## REDTAIL RANCH

### FINAL PLAT

#### LETTER OF INTENT – FINAL PLAT

DECEMBER 2018

GRADING & EROSION CONTROL PLAN

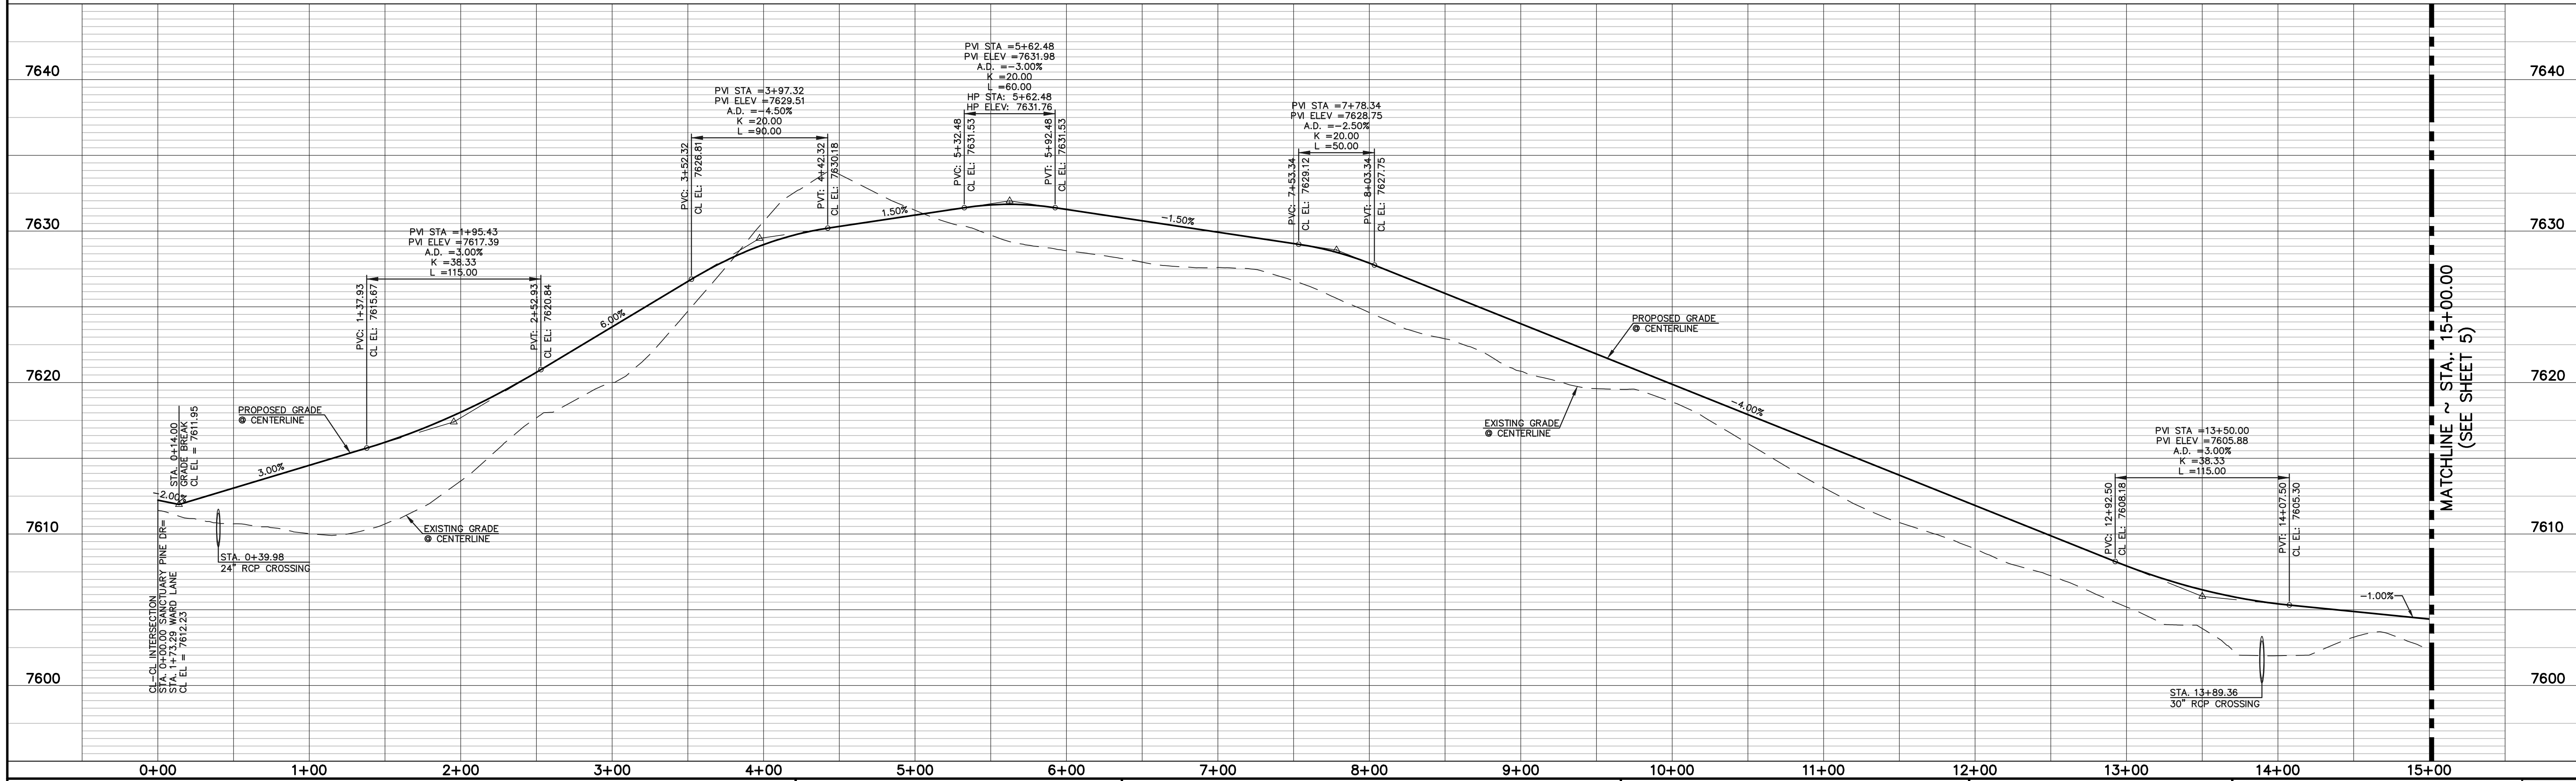
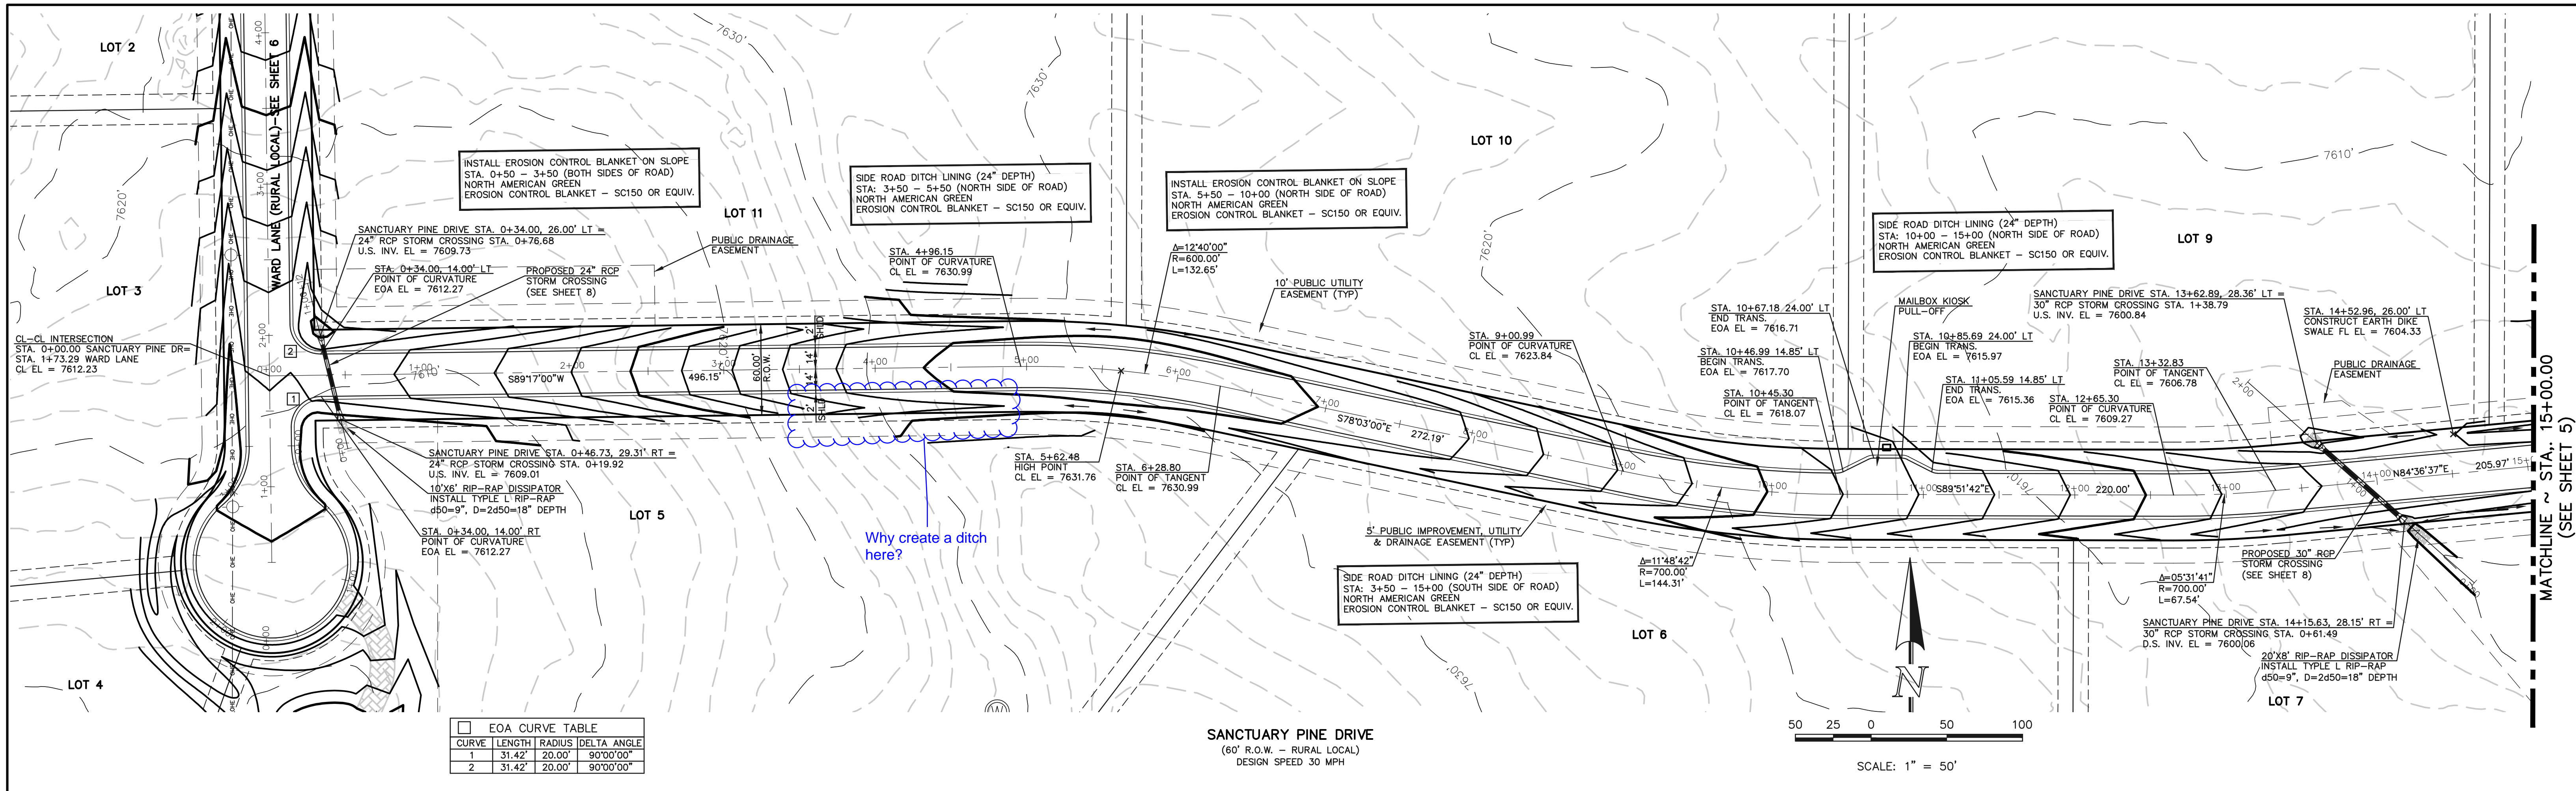
Add permanent sediment control for east end of Sanctuary Pine Dr.
